Roberts <Karl.Roberts@arun.gov.uk>
Subject: Finalised HRA for Pagham Spit

Habitats Regulations Assessment for Planning Application References P/93/21/PL (ADC) and 21/01921/FULEIA (CDC)

Drawing B

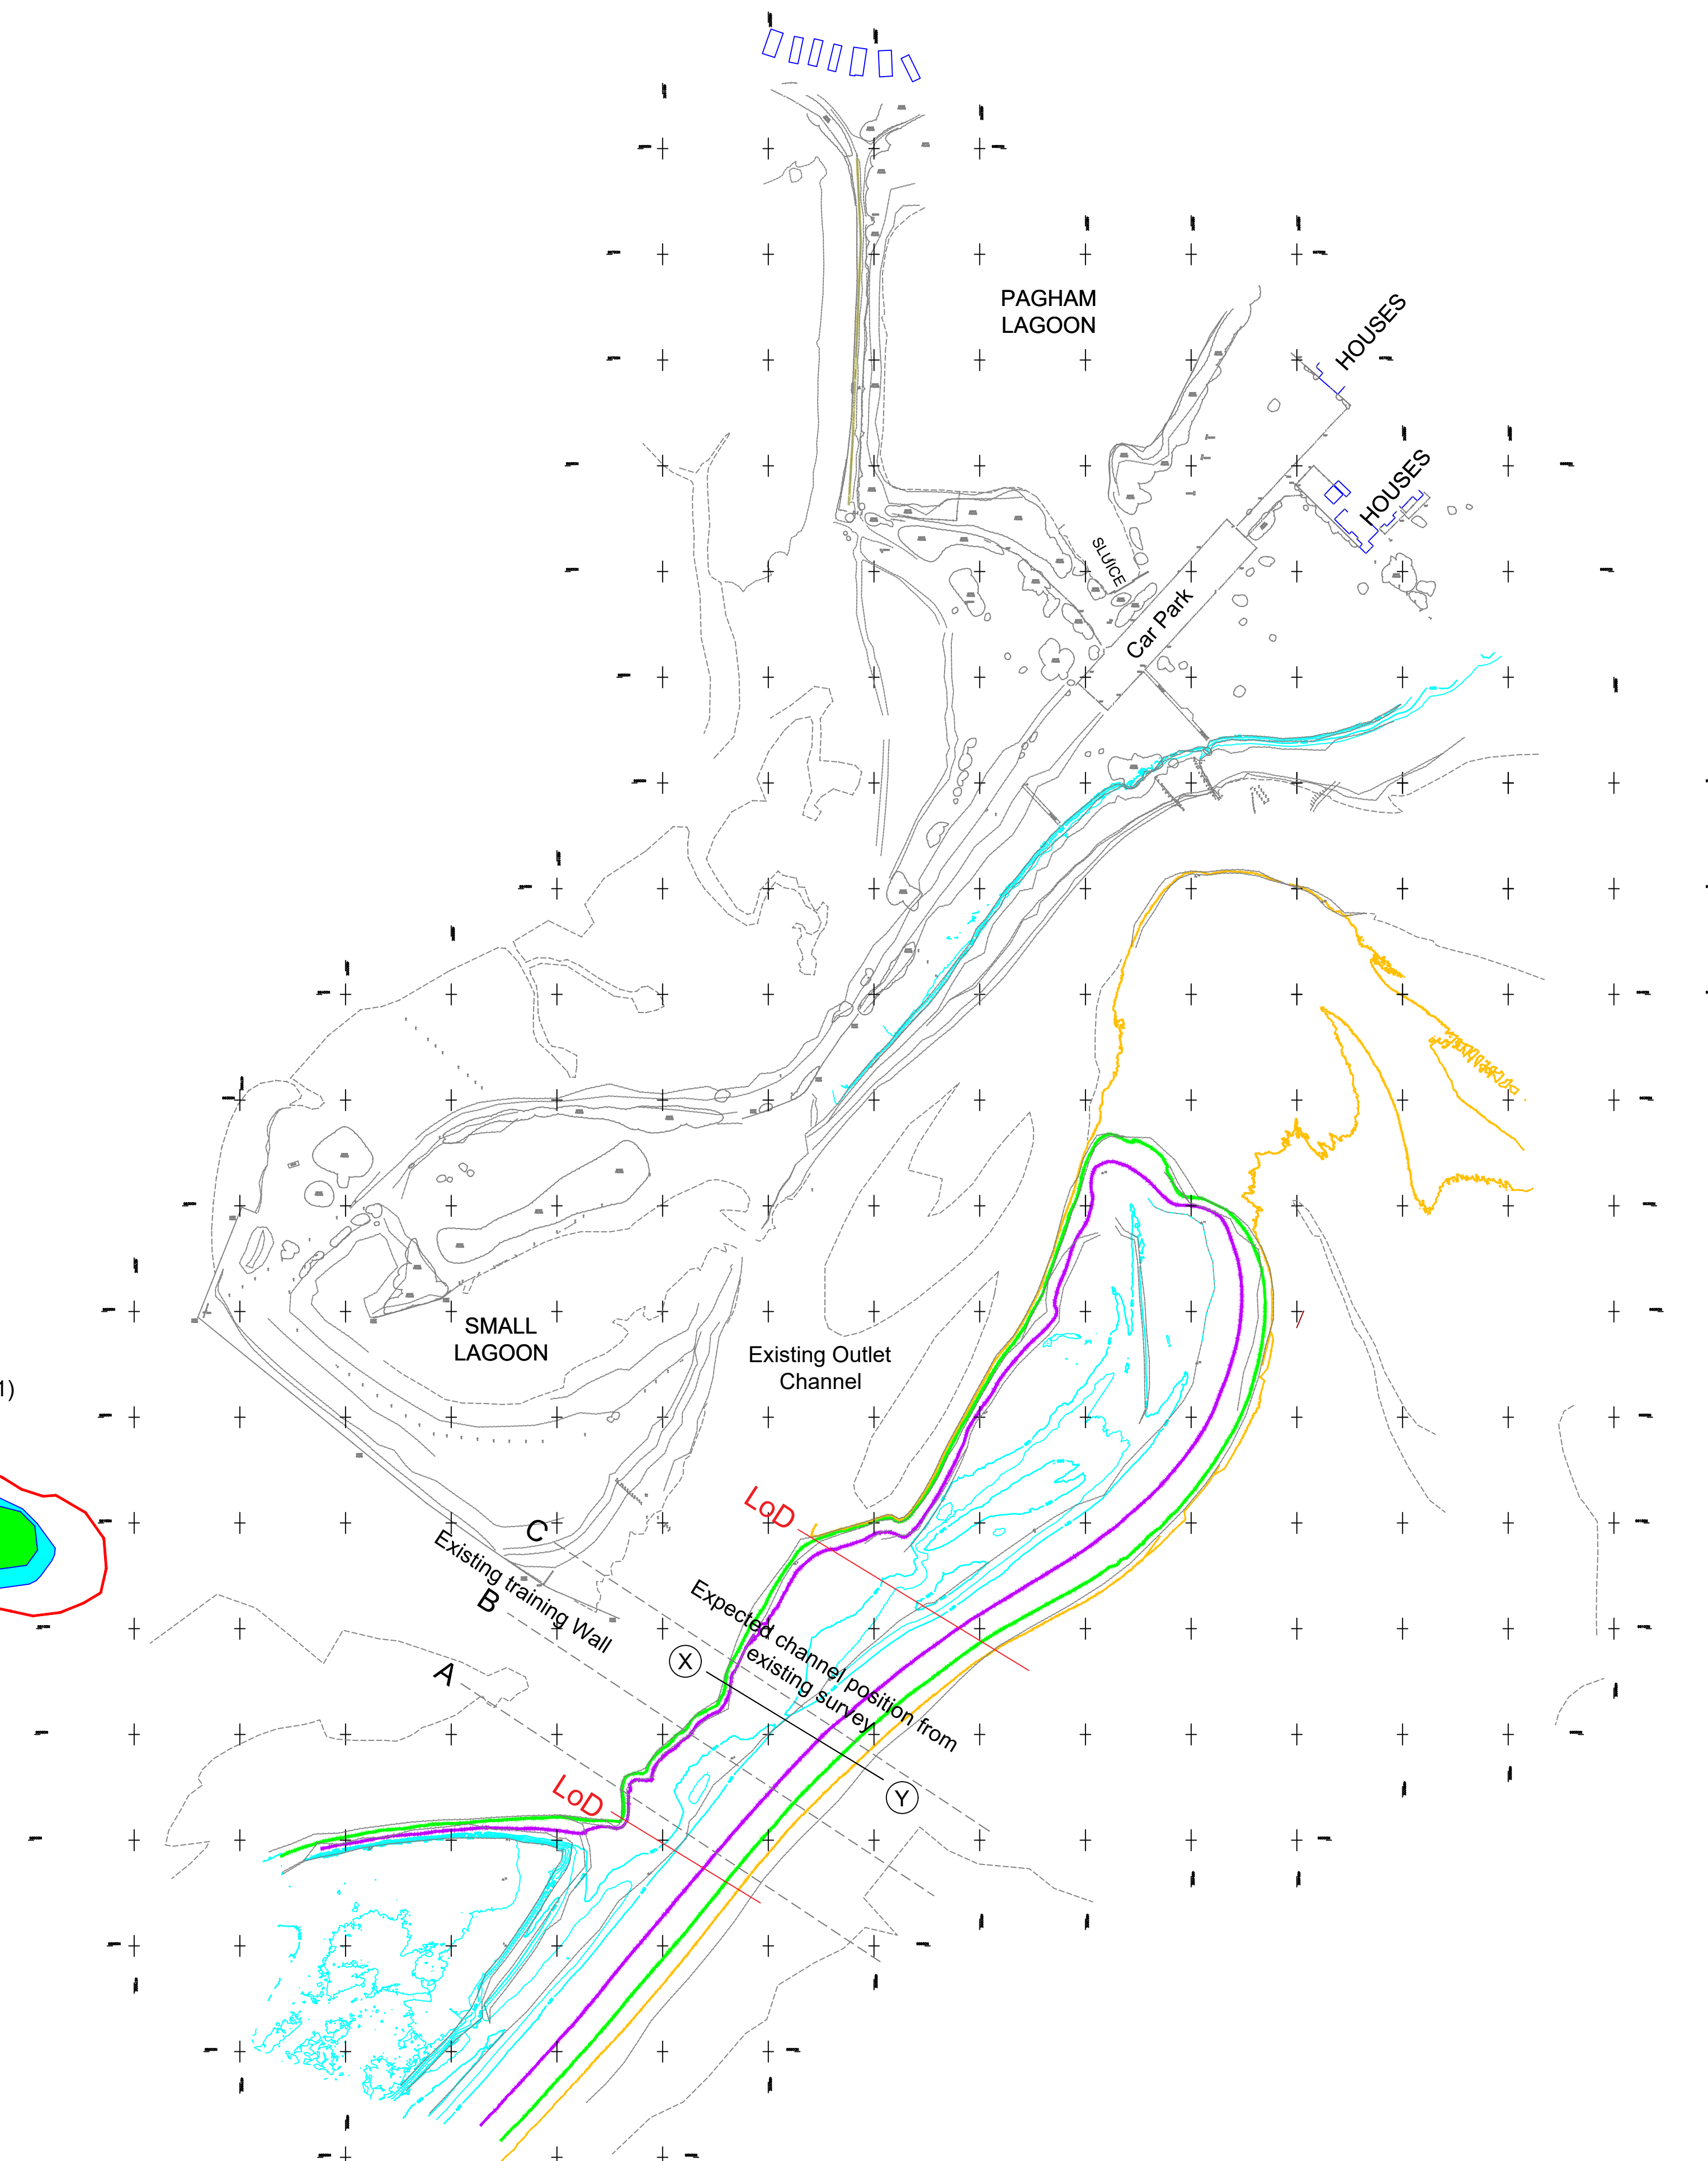
The documents submitted by the applicant propose the creation of new habitat for nesting terns by using 3,000 cubic metres of shingle from the excavated breach to raise levels on an alternative site within the harbour to create some 0.3Ha of new island. This new site is more remote from human and predator disturbance than that proposed in 2016 and does not require any access along Church Norton spit, so reducing the construction phase impacts. Provision for ongoing maintenance of the compensatory site in a suitable condition and clearance of vegetation will have to be secured.

- A) Yes, the measures are considered technically feasible (subject to any further NE advice). The design includes a crest area of 0.15Ha at 1m above MHWL and graded slopes (application Drawing B).

- E) The compensatory habitat is more sheltered than the exposed site of the spit. However, the new compensation site is more exposed to erosion due to tidal flows through the newly created project breach. Natural England have advised (e-mail 25/08/21) that "Reassurance on the likelihood of this [the island being eroded] and how this would be managed needs to set out" and a commitment need to be made to maintaining the compensatory habitat for

the lifetime of the proposal. In the event of the compensatory habitat being re-worked by natural processes, any shingle that is required to maintain it will be provided – in line with the mitigatory considerations outlined within Tables 1 & 2 – and supplied from a source outside of the designated site(s), as to further mitigate any impacts to the qualifying features of the site(s).
